18/12/2019

Our Ref: R/2015/15/E
2019/639595

**Section 4.55(2) modification to SSD 7037
75-85 Harrington Street, The Rocks**

In respect to.....SSD 7037.....

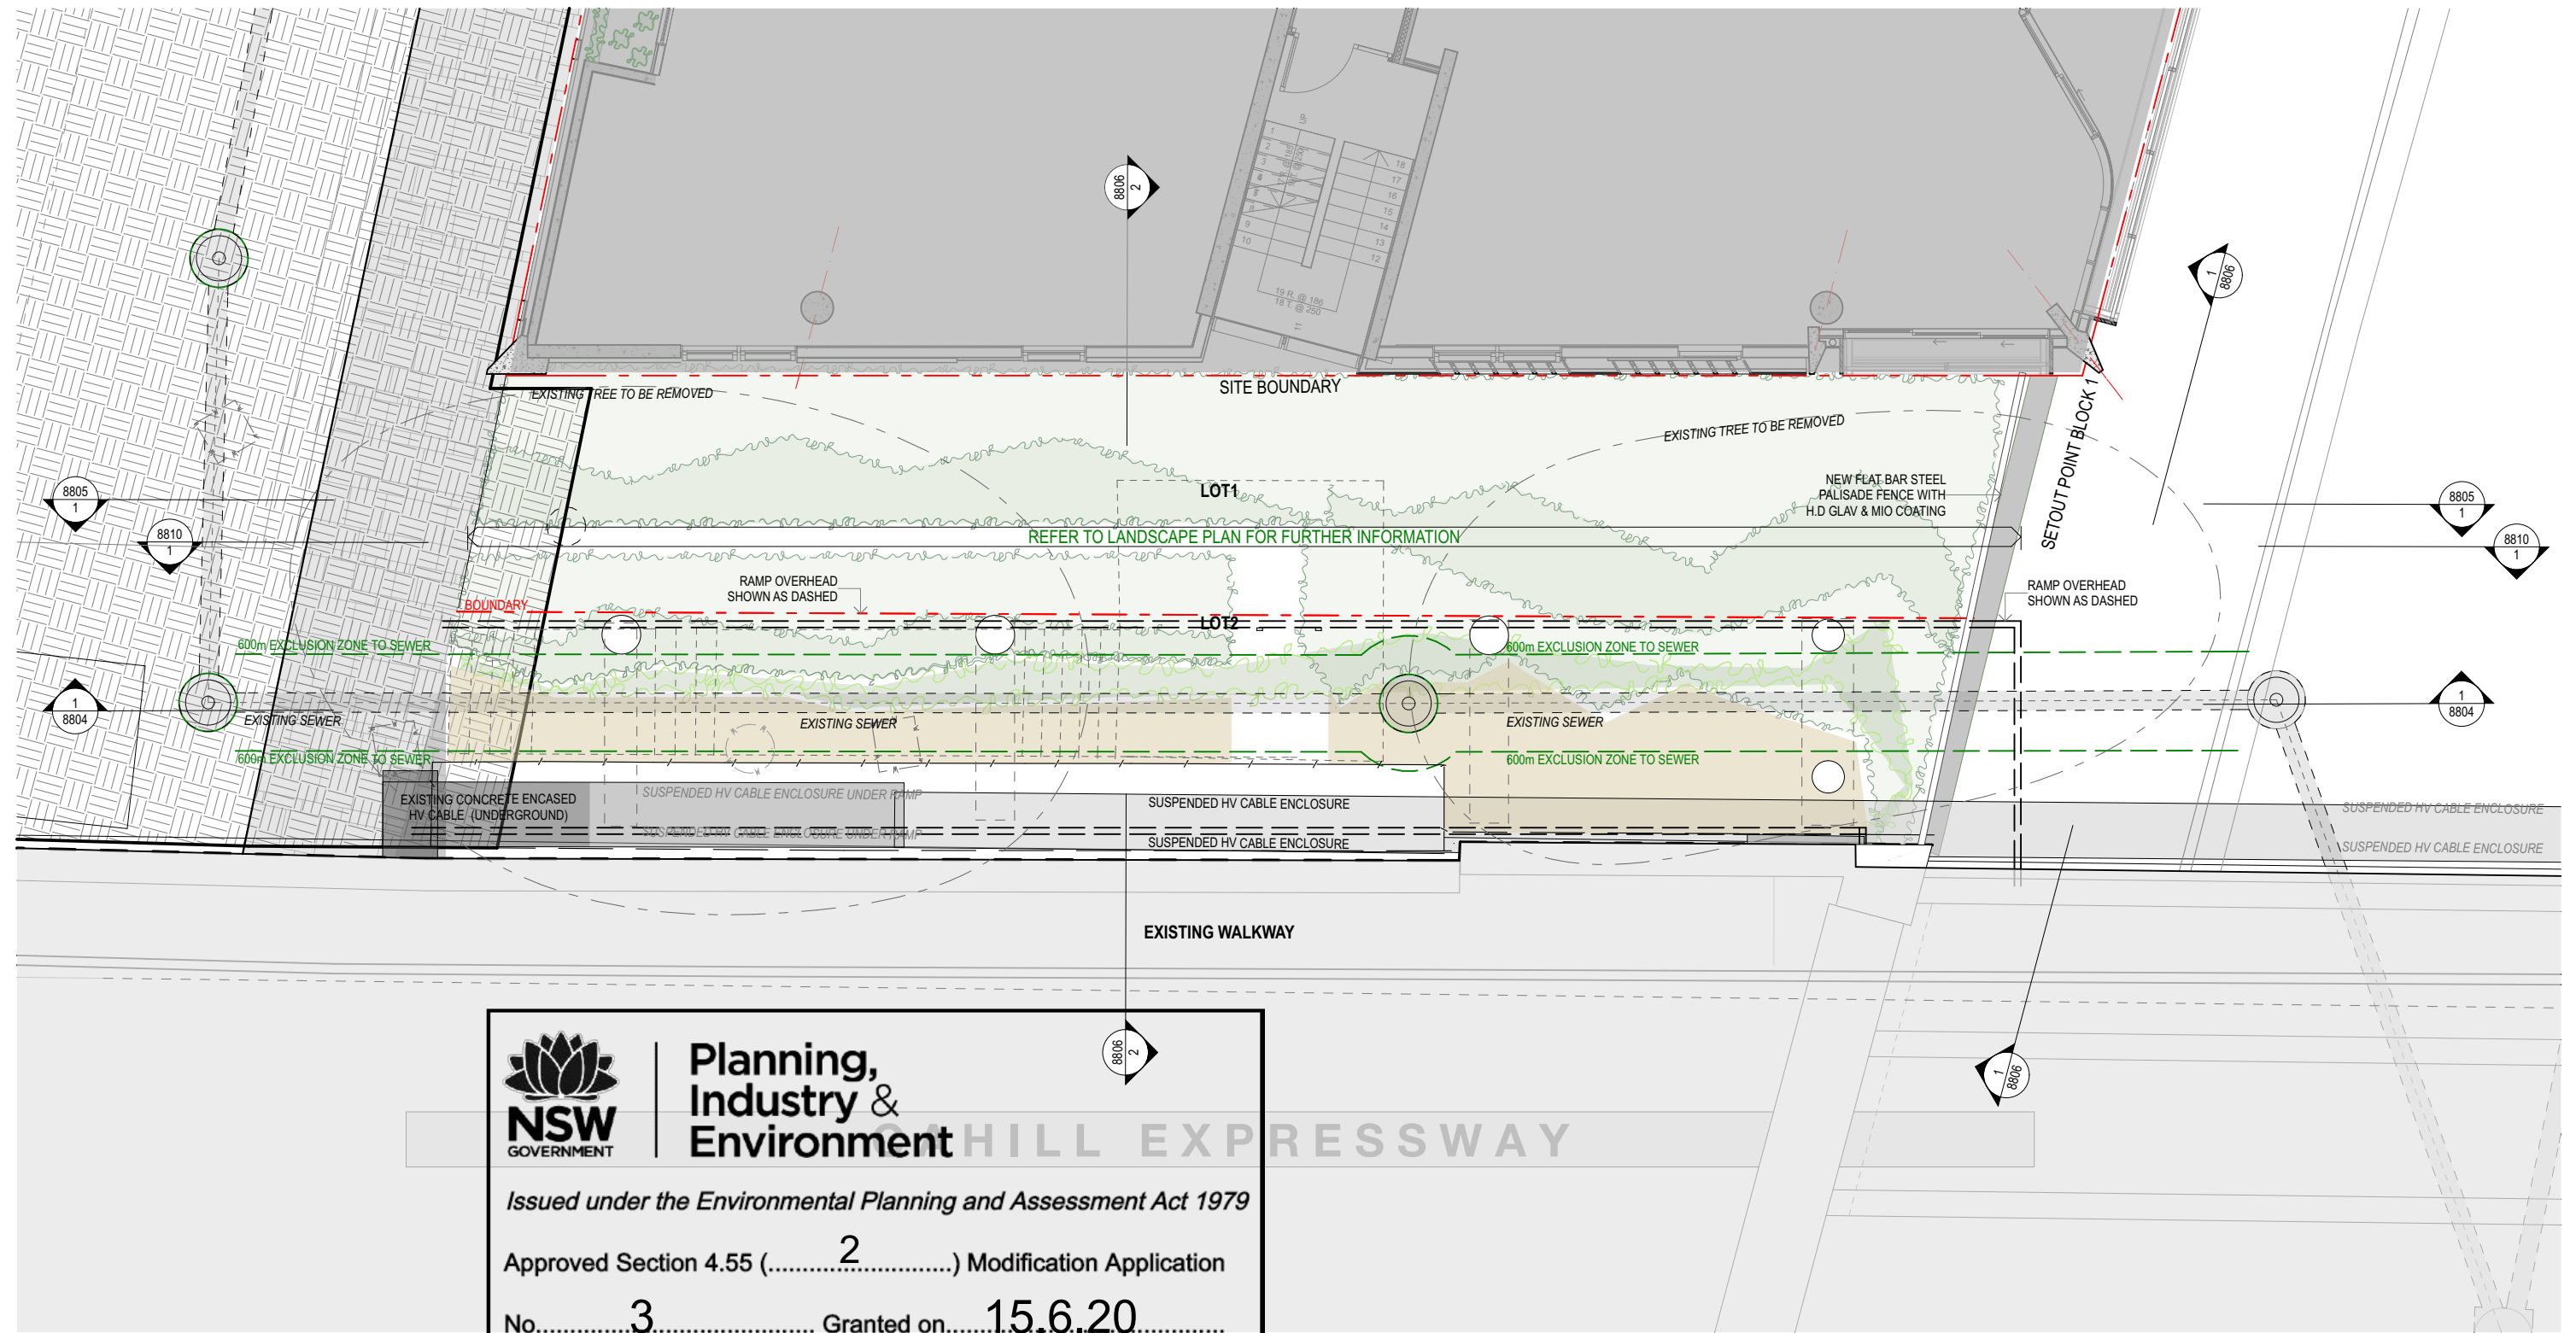
The long promised ramp is very welcome, and is not only a part of the City of Sydney's *Cycle Strategy and Action Plan 2018-2030*, as mentioned, but is also a key link in the NSW Government's *Sydney City Centre Access Strategy* (2013).

The *Sydney City Centre Access Strategy* has three east-west bike routes across the city centre, the northern one being alongside the Cahill Expressway. This project should provide the missing access to the State government's Cahill Expressway bike route – including for people riding who have children with them or on their bikes and those who have a disability and use their bikes as a mobility aid.

As such, it is not appropriate to have a discontinuous facility which requires or forces people to dismount. The Department of Planning Industry and Environment should ensure that this new infrastructure is fit for purpose and fulfils NSW Government strategies and plans, and is consistent with its original intent.
